Objection Letter (Updated with CDC, Survey Evidence, EIS Inconsistencies, Structural Risk & Sunlight/Shadow Issues)

To: NSW Department of Planning, Housing and Infrastructure Re: SSD-83478456 - Residential Development (21-25 McIntosh St & 55 Werona Ave, Gordon) From: Owner - 12 Forsyth Street, Killara NSW

1 Section A
1:200

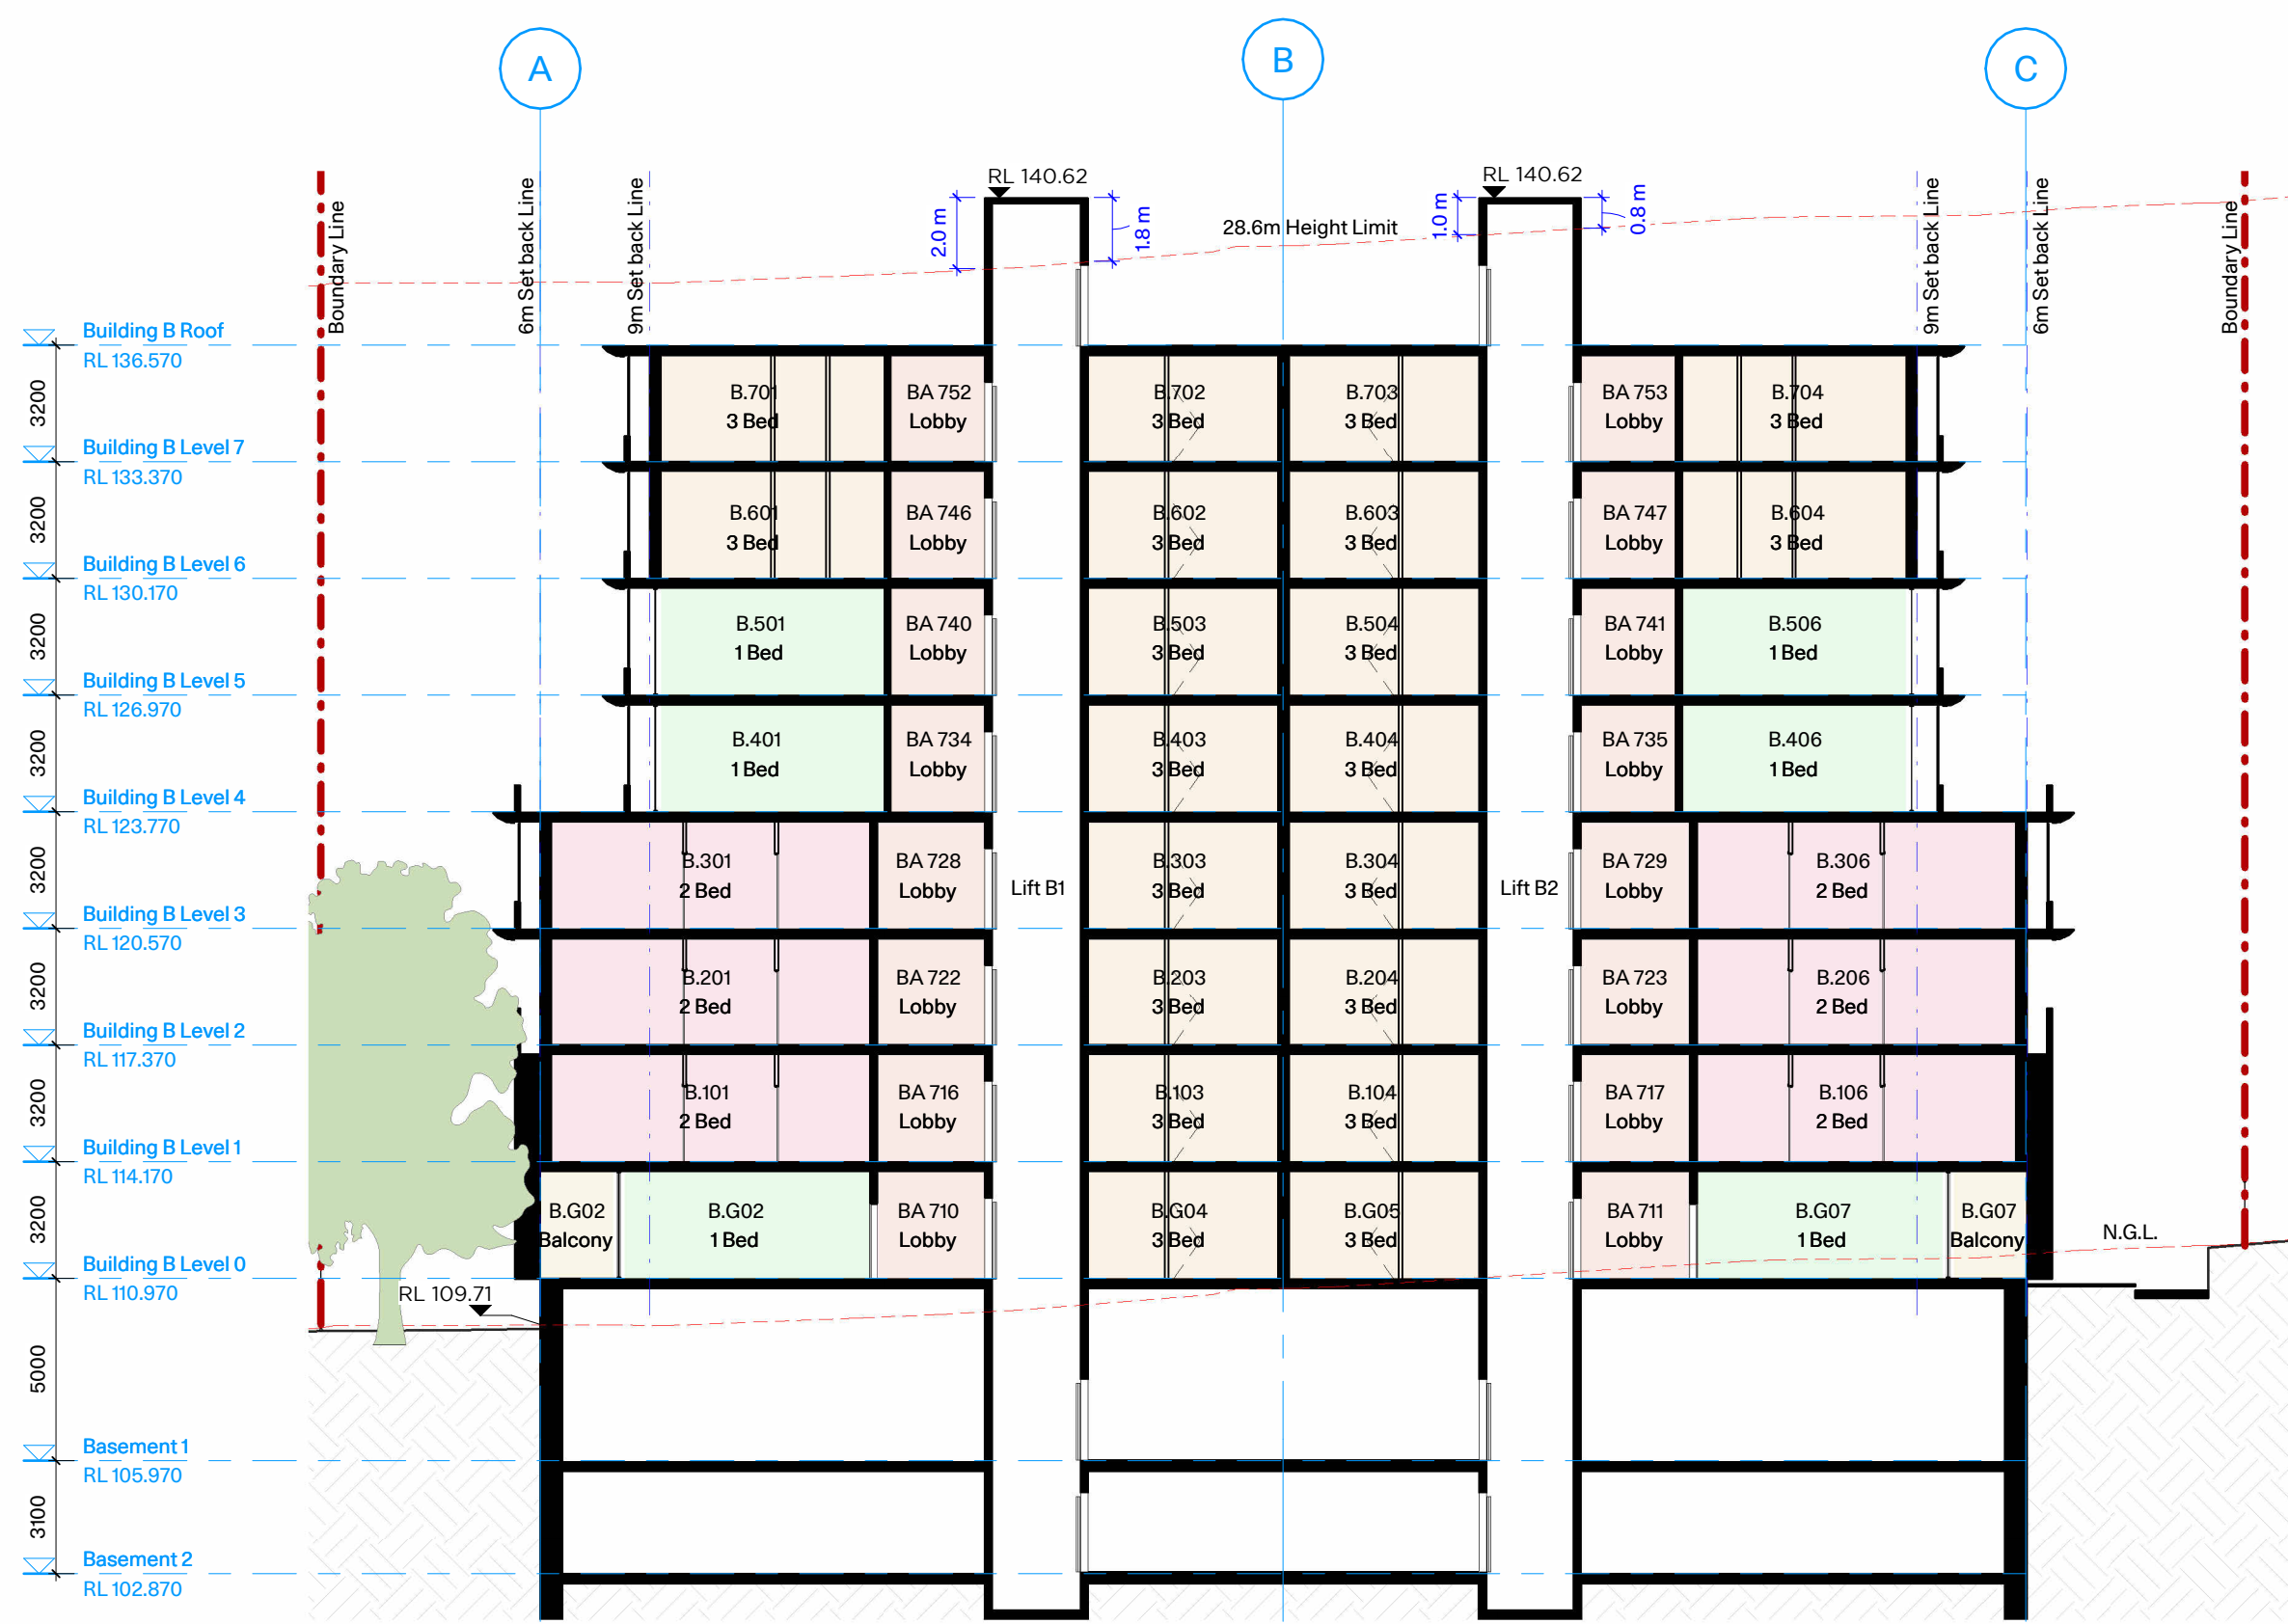
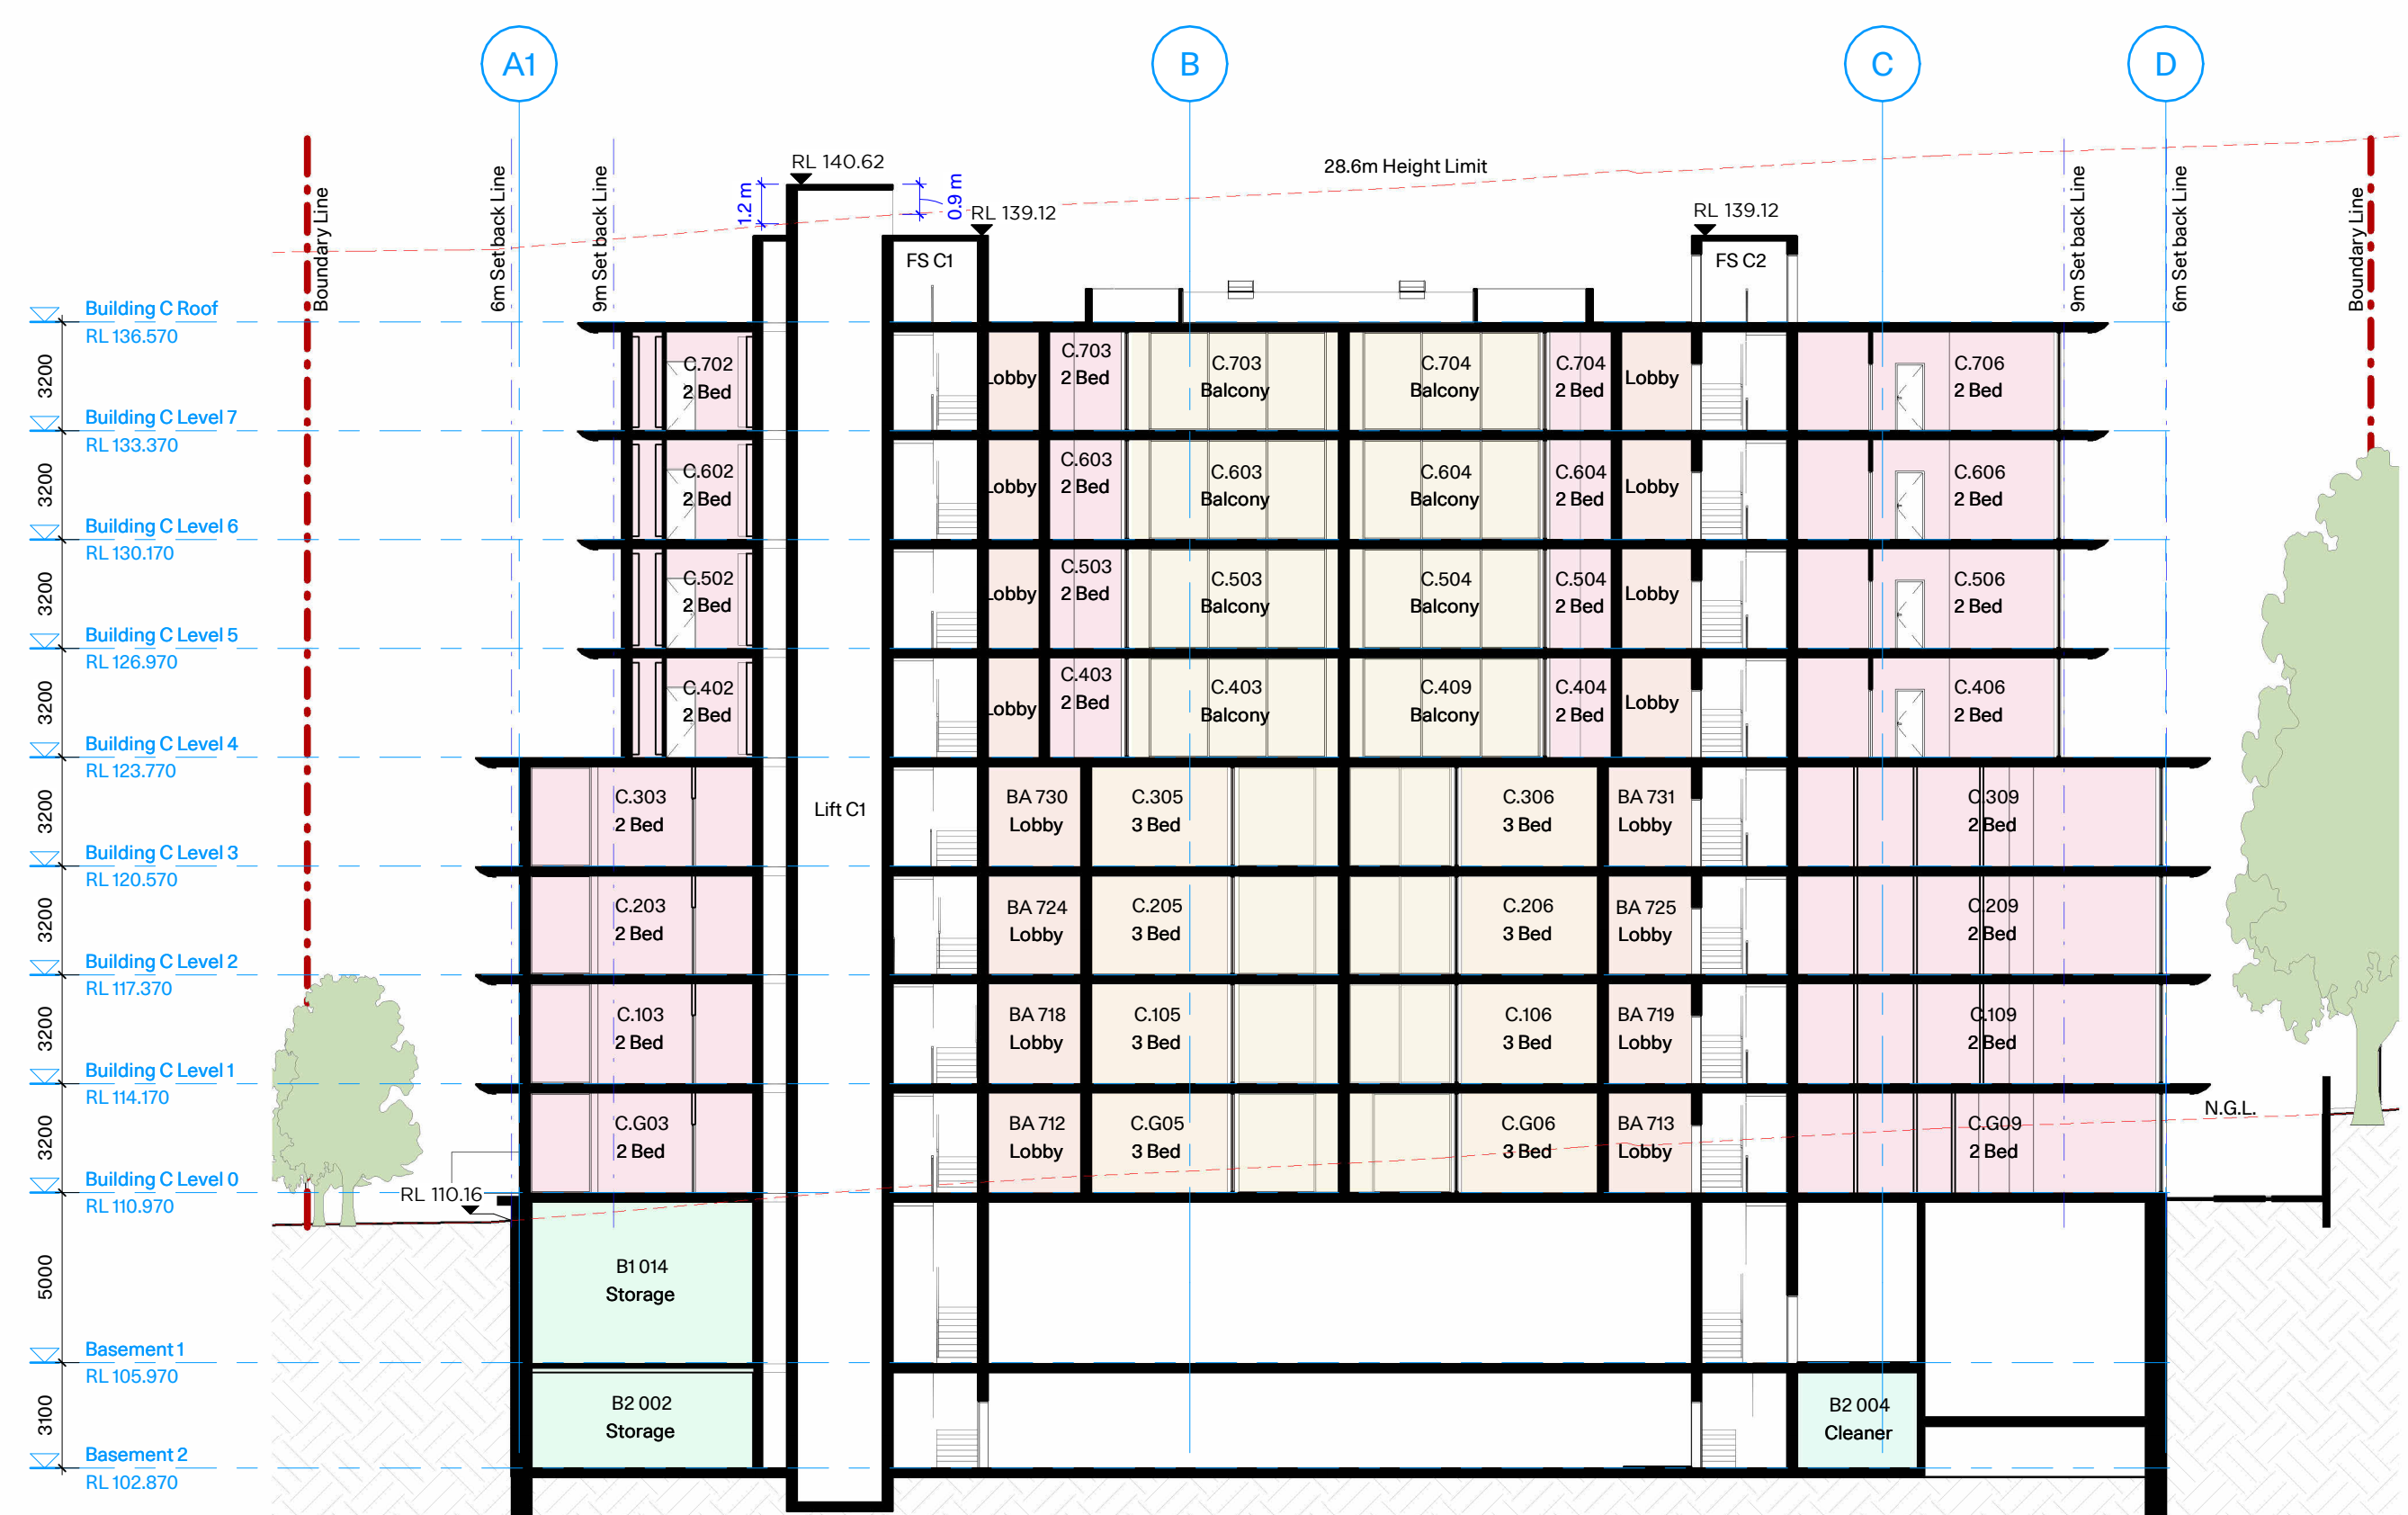
- **Fact:** The proposal seeks heights of up to 30.5 m (Appendix B - Statutory Compliance Table, page 12), above the TOD limit of 28.6 m.
- **Clause 4.6 Request:** The applicant relies on Clause 4.6 of the Ku-ring-gai Local Environmental Plan 2015 to justify this breach. Clause 4.6 allows flexibility only where strict compliance is unreasonable or unnecessary, and where better planning outcomes are achieved. In this case:
 - The objectives of the height control (protecting neighbourhood character, preventing overshadowing, preserving amenity) are not met.
 - The exceedances (up to 6.6% or 1.9 m for lift overruns and roof spaces) provide no genuine public benefit and instead cause

- adverse amenity impacts.
 - The request is therefore both unreasonable and unnecessary.
 - **Comparison:** My CDC-approved house ridge height is only 8.5 m (CDC Stamped Plans, Elevations, pages 5-6).
 - **Impact:** Their proposal is nearly three times taller, overwhelming the low-density streetscape and undermining the intent of planning controls.
-

1. Reduce overall height to ≤ 5 storeys (≤ 17 m to top of parapet) across all buildings.
2. If not feasible, step down the block closest to Forsyth Street by $\geq 2-3$ storeys, and increase the southern setback so that overshadowing to 12 Forsyth St is mitigated to ≥ 3 h midwinter.
3. Remove/shorten lift overruns, rooftop plant rooms, and balustrades so that no element exceeds the 28.6 m control.
